**ANGEL PLACE
LEVEL 8, 123 PITT STREET
SYDNEY NSW 2000**

4 May 2021

DESIGN INTEGRITY PANEL MEETING - 8-10 LEE STREET, HAYMARKET [SSD-10405]

DRAWING
SHED - SOUTHERN
ELEVATION
DOCUMENT NUMBER
DA-11C-GXX-02
ISSUE
6

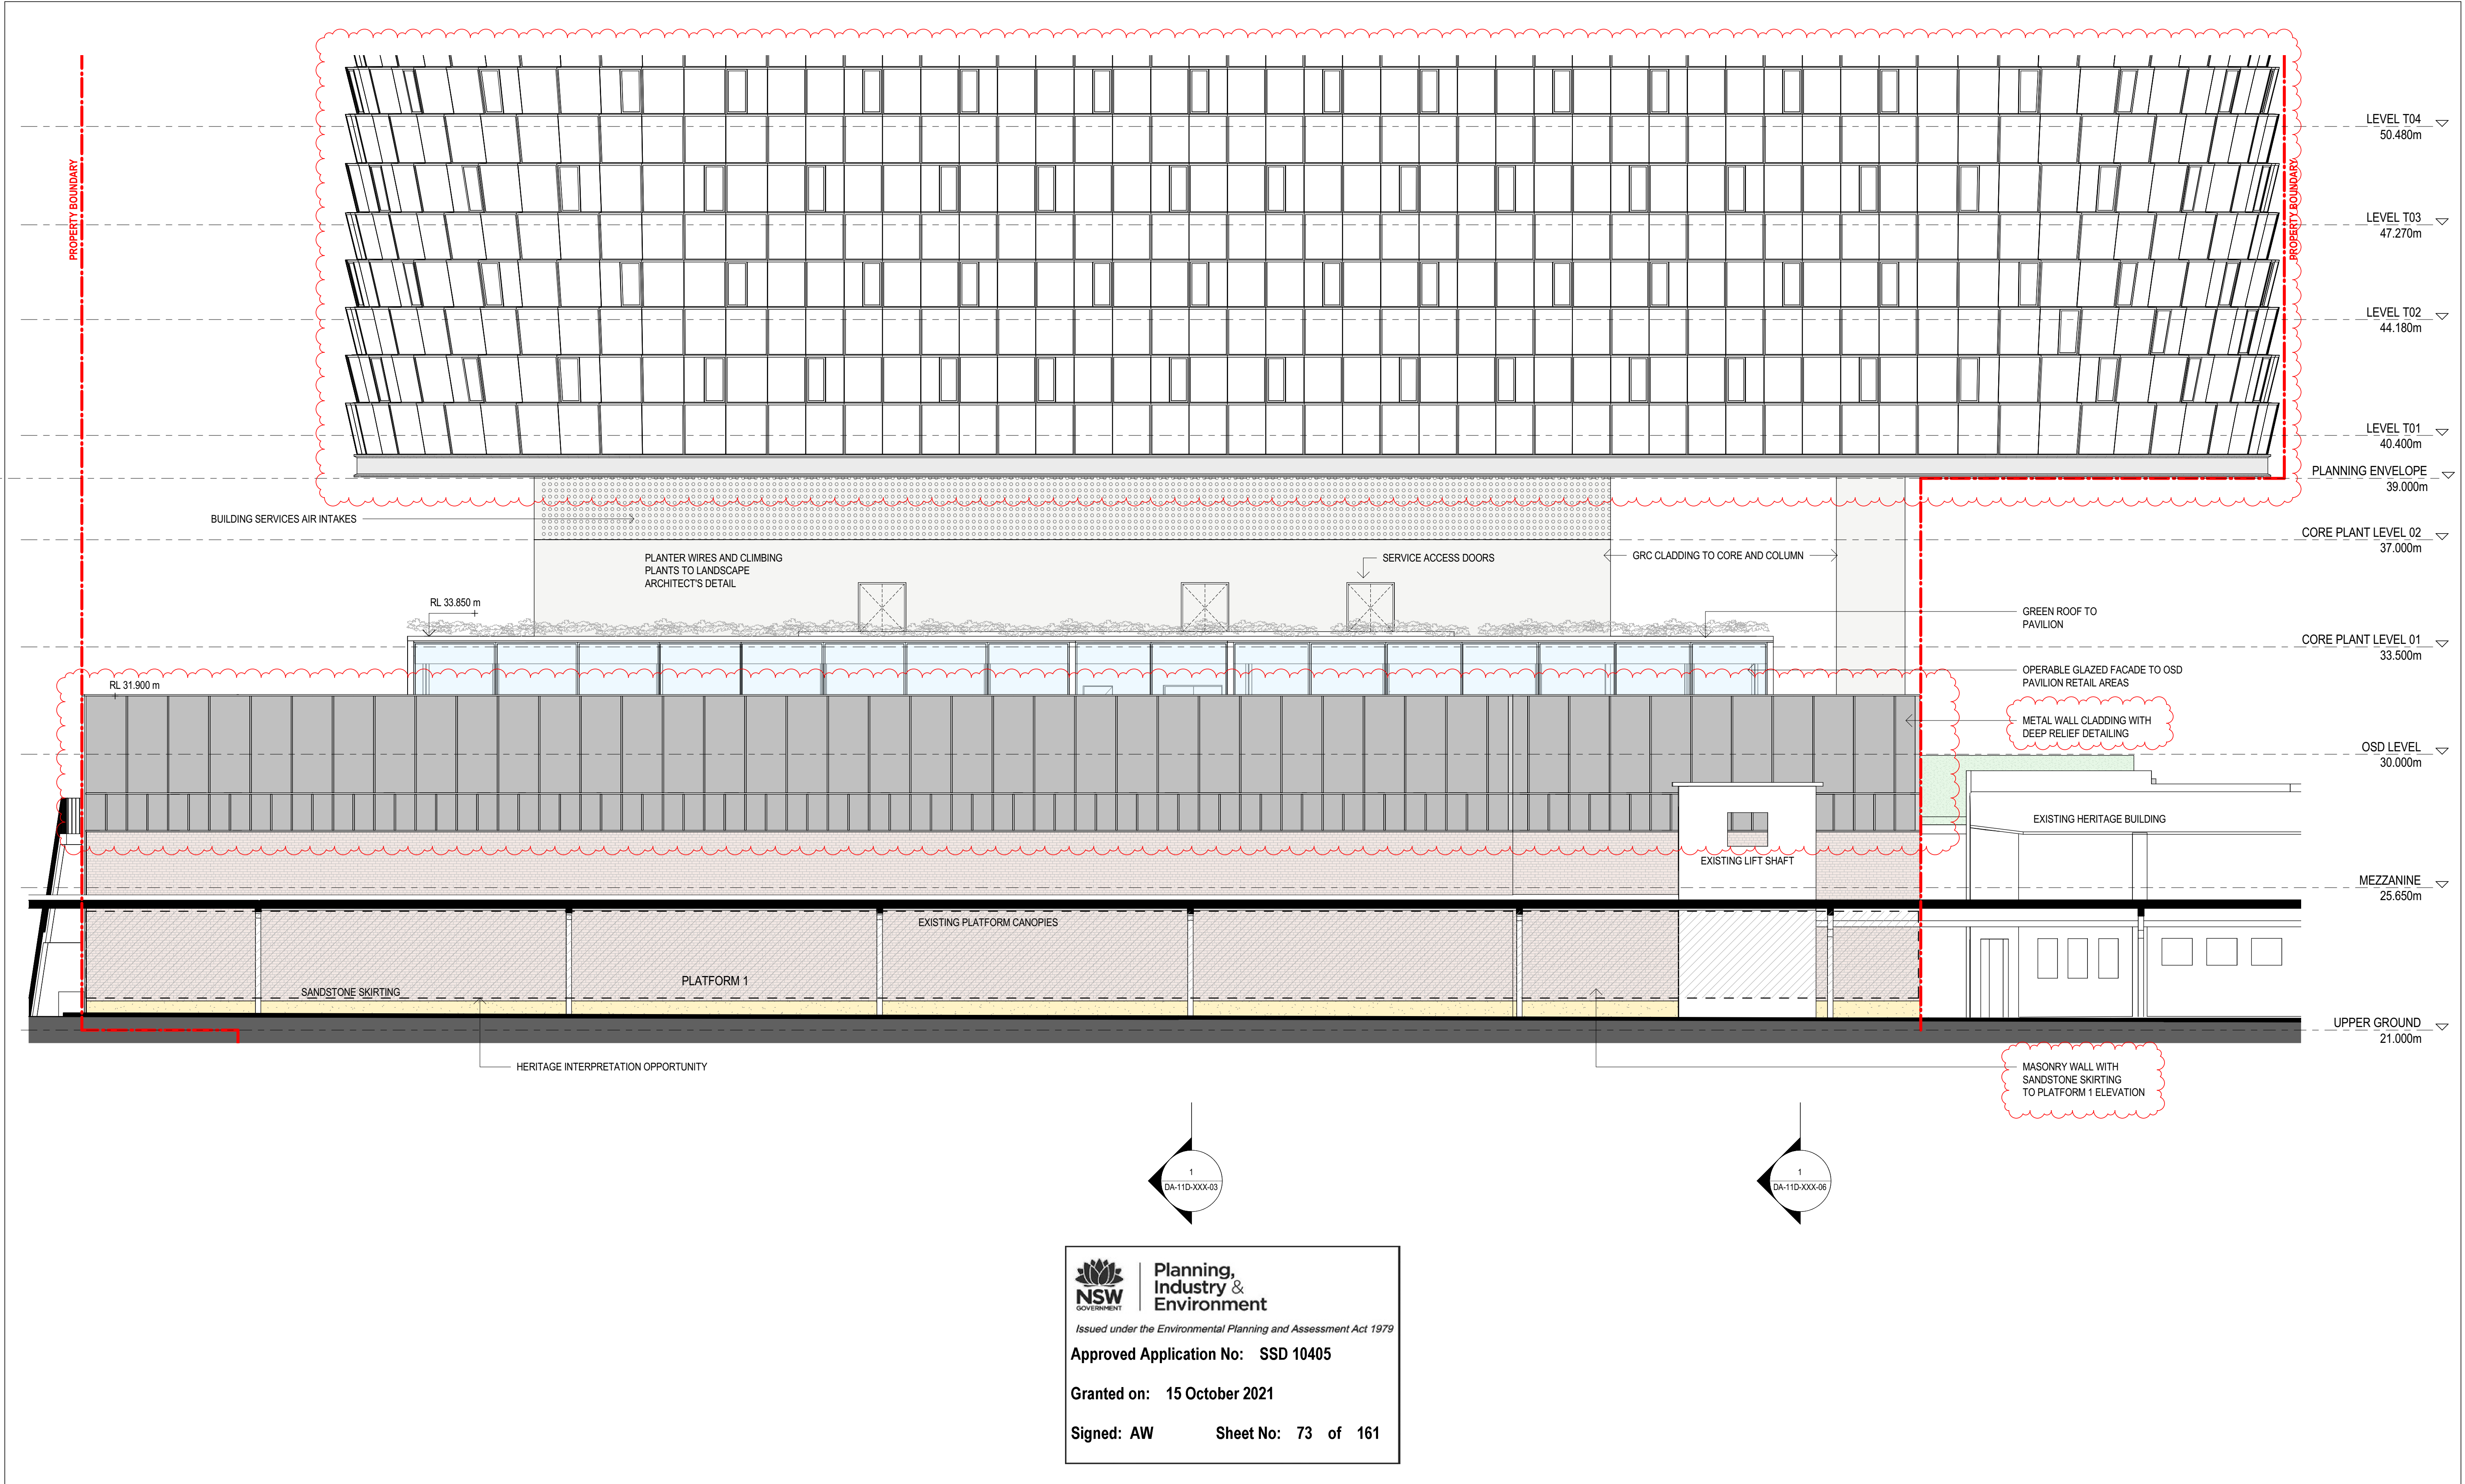
<p>External Staircase – Need to further consider the resolution of the external staircase located on the southern elevation of the shed, particularly if it is to remain as a more permanent structure, due to the potential visual impact on the readability of the shed.</p>	<p>Relocation of external stair is broadly supported. This is aided by the proposal to cut back the glazing to reveal the cantilevered roof line.</p>
<p>Northern elevation of Shed – Further resolution is to be explored for the northern elevation of the shed to ensure the internal shed structure remains visible and legible whilst managing the internal comfort of the Atlassian lobby.</p>	<p>The panel are broadly in support of the design amendments.</p> <p>The reeded glass is an elegant solution to the industrial interpretation of the original shed.</p> <p>The panel notes that the proposal must ensure that introduction of ‘slick’ or contemporary details should not erode the industrial quality from which the character of the site originates.</p>
